**OUR REFERENCE:**  
5161805-21-CO-00953

**YOUR REFERENCE:**  
ACP-324447-26

**Subject : Proposed Upgrades to Mortarstown Wastewater Treatment Plant and Kilkenny Road Pumping Station, Carlow, County Carlow**

We refer to the Commission's correspondence inviting a submission on the eight observations received in respect of the above application. This response is confined to the issues raised in those observations and relies on the application documentation already submitted. No additional or supplementary report accompanies this response.

| P      | 5161805_EWE_DR_MOR_5103 | 0   |

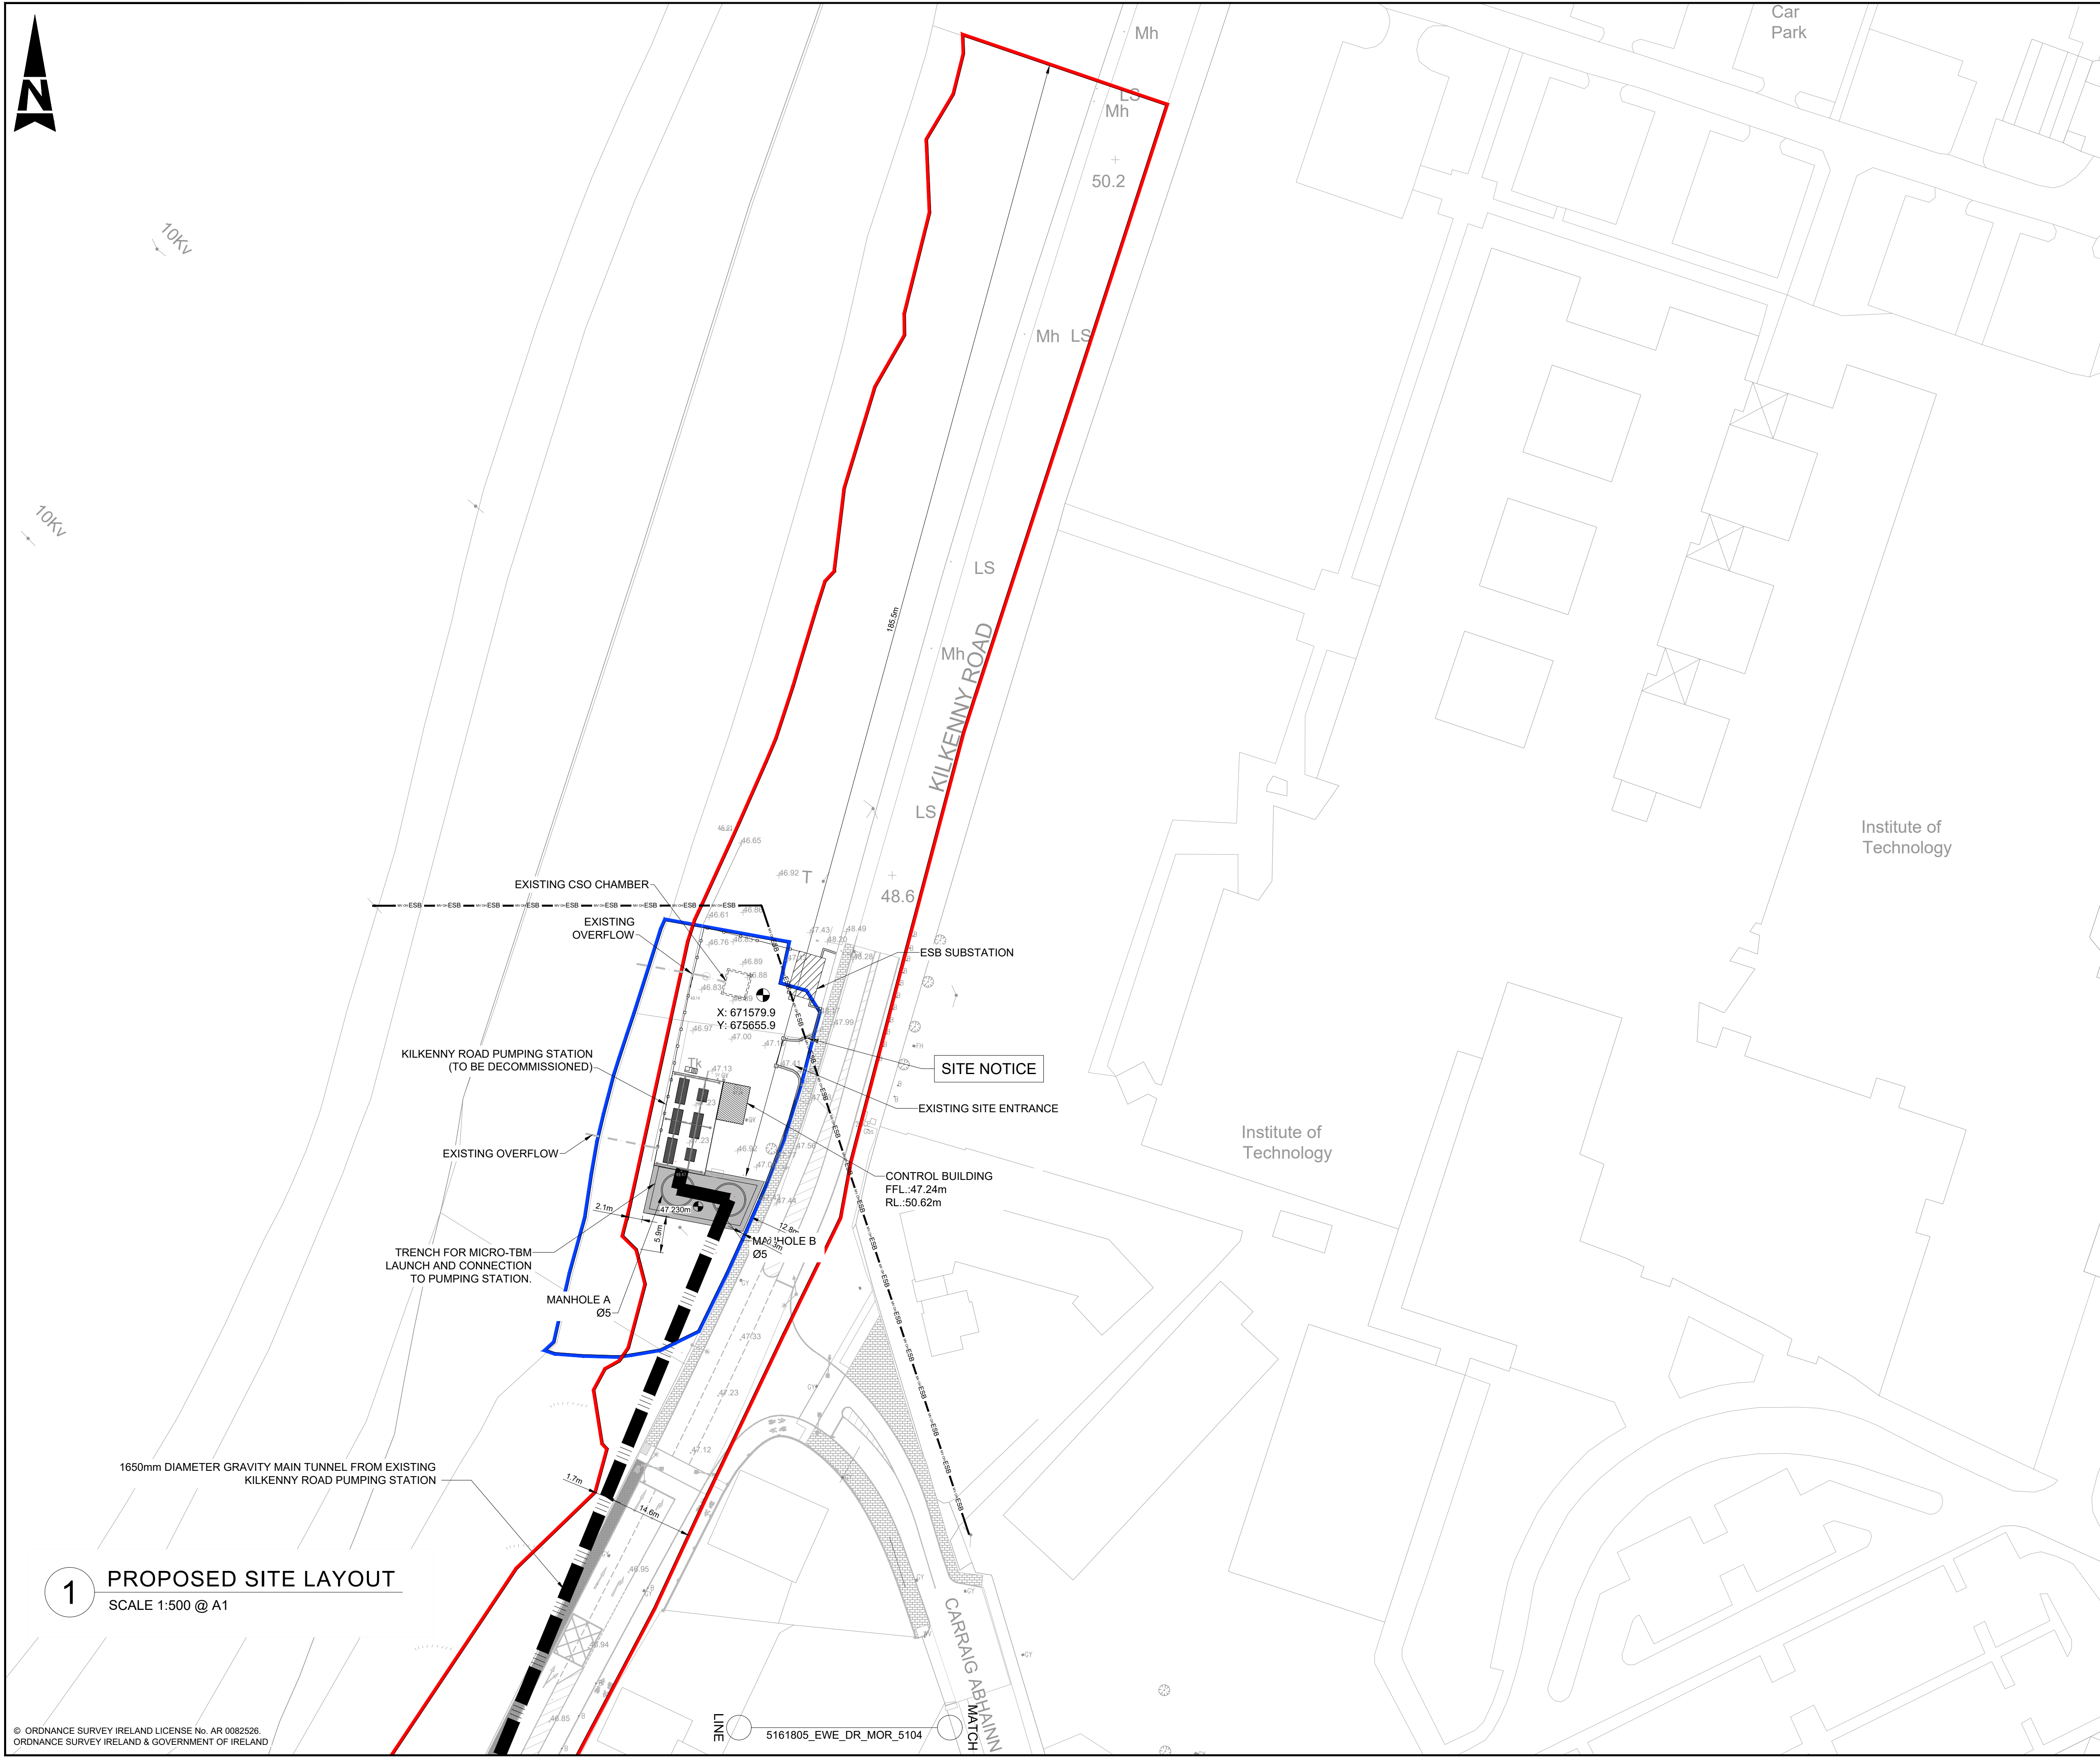
The concern regarding private property is acknowledged. During the public consultation, the property owners raised similar concerns regarding the encroachment of the proposed tunnel alignment within the property boundary at Eircode R93 T3Y2. In response to the feedback received during the public consultation, the tunnel alignment was reviewed and subsequently adjusted to ensure that the tunnel and all associated infrastructure are located wholly outside the boundary of this property.

Drawings 5161805/EWE/DR/MOR/5103 and 5161805/EWE/DR/MOR/5122 demonstrate that the tunnel alignment is located wholly outside the property boundary, with the nearest intermediate shaft ('Manhole E') located within the northbound lane of the R448 Kilkenny Road, opposite the property.

The pipeline will be constructed using trenchless techniques. No temporary or permanent works are proposed within the referenced private property, and the development does not rely on acquiring rights over that property.
